## **DEPARTMENT OF PUBLIC WORKS**

### **MEMORANDUM**

TO: All Staff  
FROM: Public Works Planning Review Team  
DATE: November 23, 2020  
SUBJECT: BL-20-00024 Flowers

The Public Works Department has reviewed the Boundary Line Adjustment Application.

UNIFIED SITE PLAN
FOR
TAX PARCEL NUMBERS 832534 AND 221136
FOR
BEN & LINDSEY FLOWERS

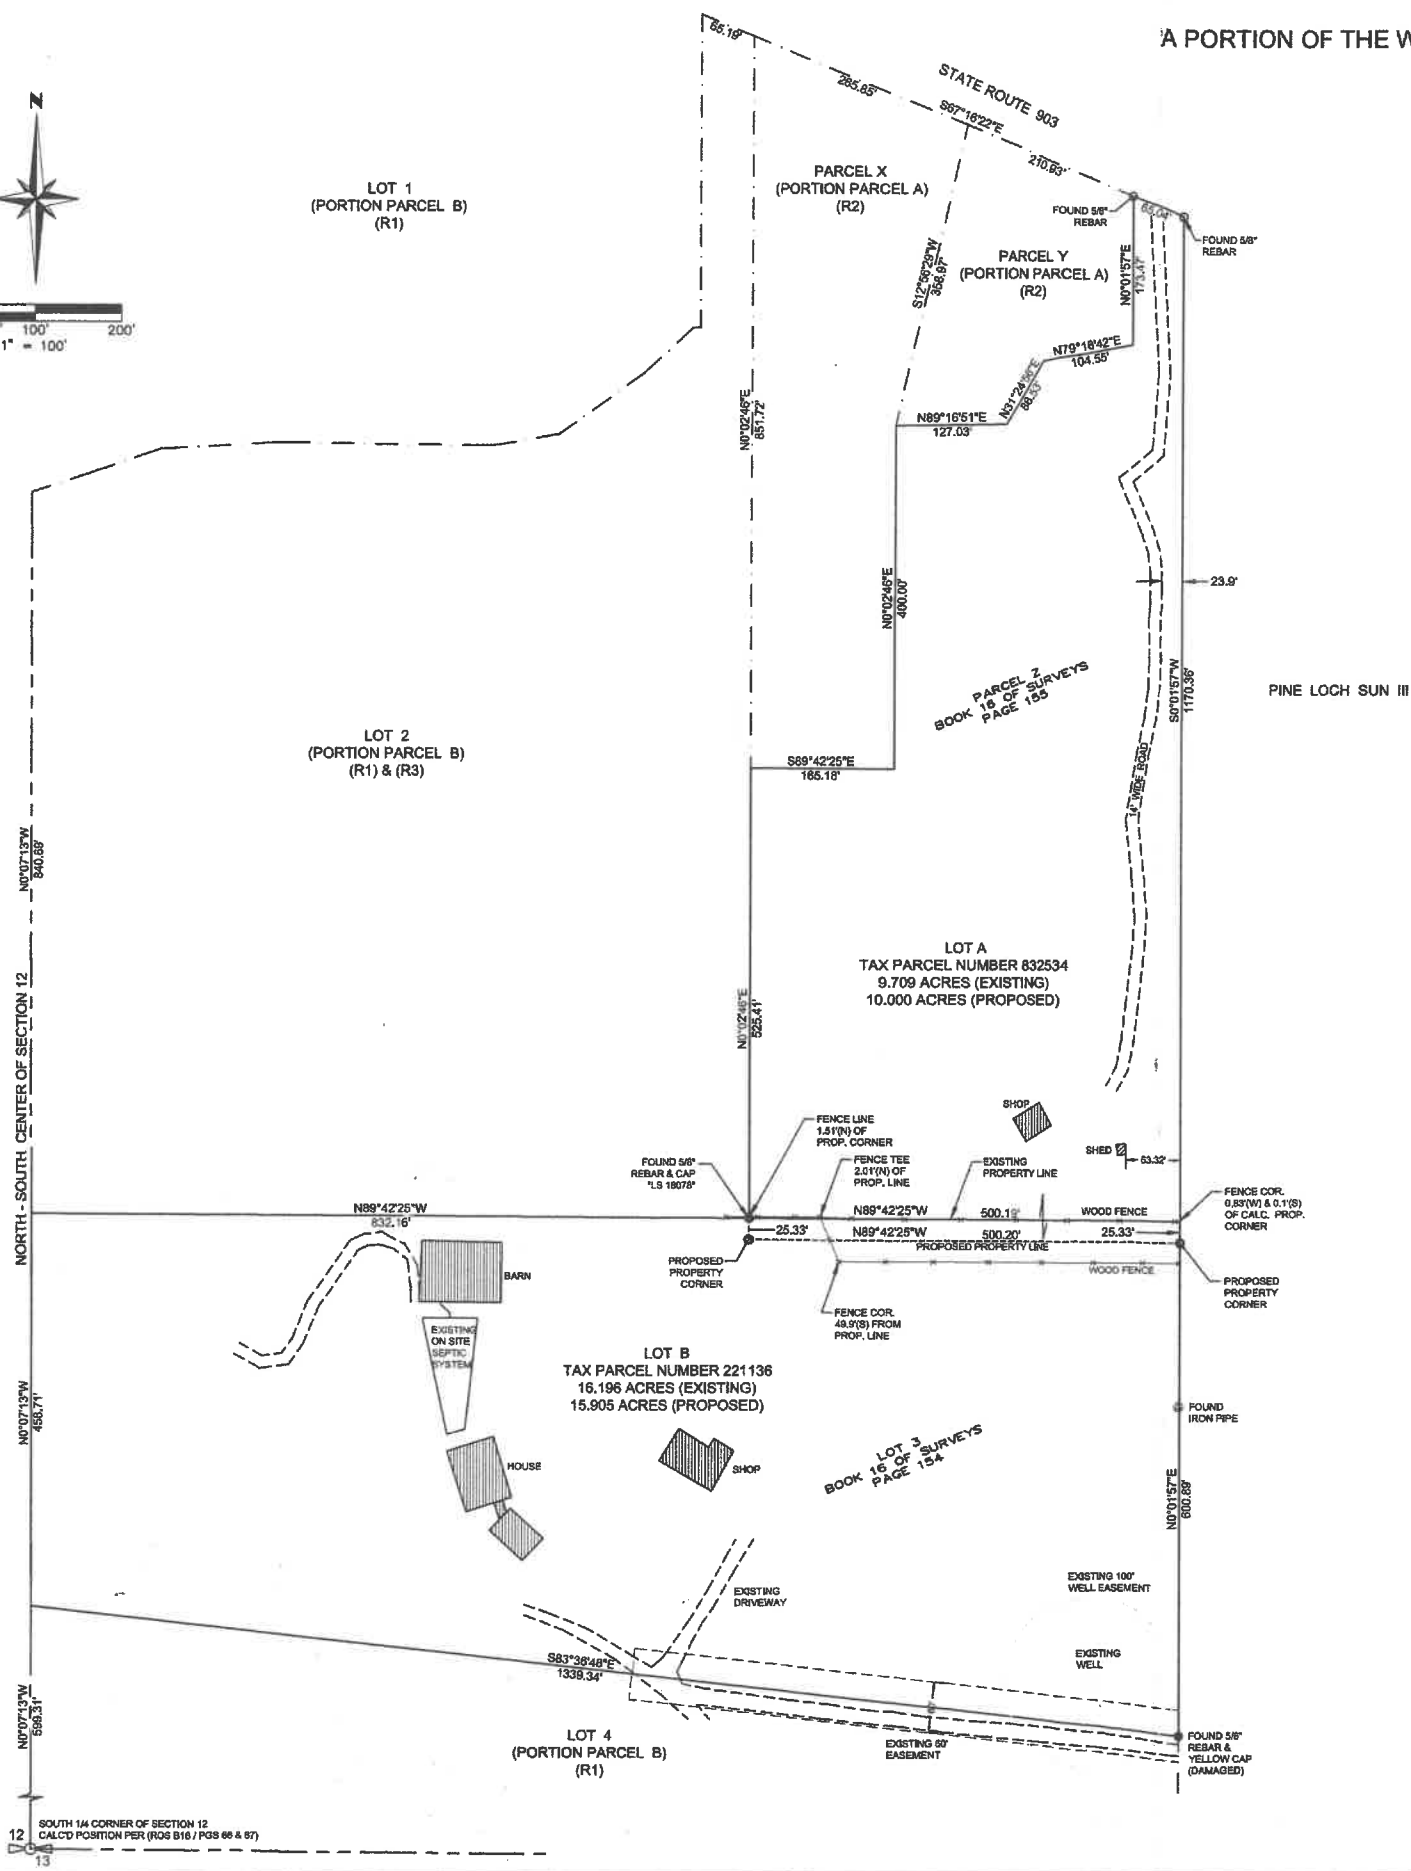
- a. Any access easements shall be shown on the face of the BLA
- b. Any newly created access, or a change in existing access, will require an access permit from the department of Public Works. An approved access permit from WSDOT is also required for any proposed access to SR 903.
- c. Maintenance of driveway approaches shall be the responsibility of the owner whose property
- d. Any further subdivision or lots to be served by proposed access may result in further access requirements. See Kittitas County Road Standards.
- e. Evidence of existing access and/or evidence of access to be created should be confirmed prior to sale of property.
- f. Access is not guaranteed to any existing or created parcel on this application.
